**From:** Cotton Consulting <cotton.consulting@live.co.uk>  
**Sent:** 09 March 2022 07:11  
**To:** Cotton Consulting  
**Subject:** FW: 157 The Street, Stoke Ash: DC/20/04856  
**Attachments:** Magnolia Cottage 157 (Gary Godbold).docx; Magnolia Cottage 157 (fire barrier battening and aris).docx; Window Sections.pdf

From: Thomas Pinner <Thomas.Pinner@baberghmidsuffolk.gov.uk>  
Sent: 01 February 2021 17:18  
To: Cotton Consulting <cotton.consulting@live.co.uk>  
Subject: FW: 157 The Street, Stoke Ash: DC/20/04856

Title
Mullion Window typical
Glazing Section

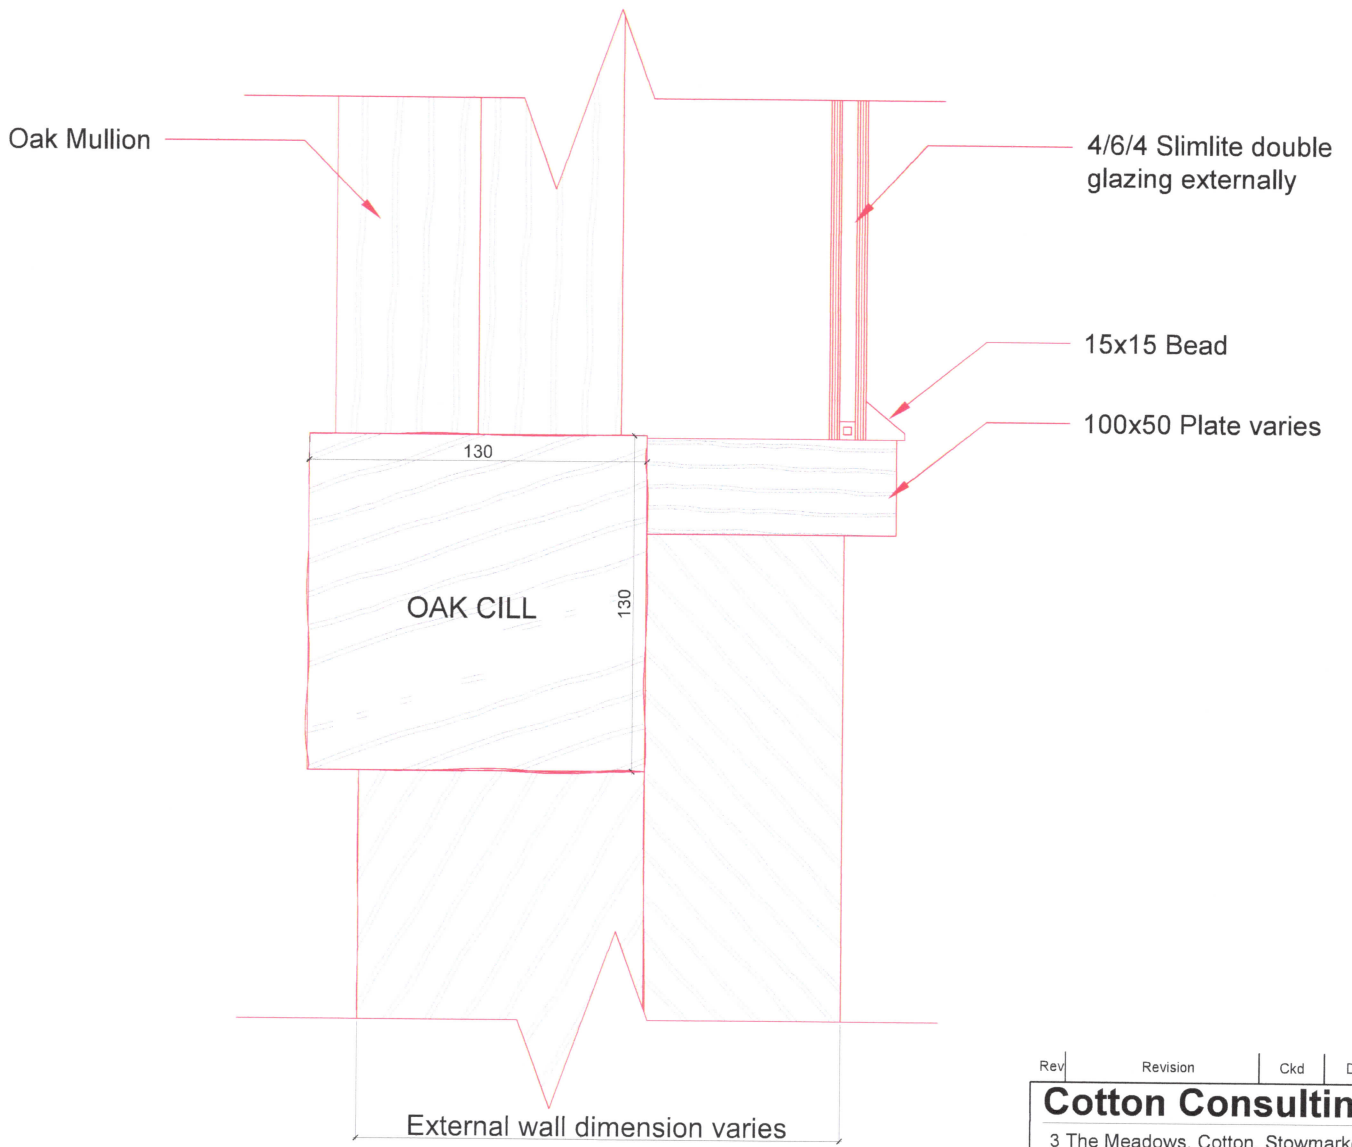
Windows - The section drawings look acceptable in heritage terms. You may wish to consider a larger rebate for the putty beading from a quality perspective though, as the rebate shown is fairly minimal so may be more prone to decay.
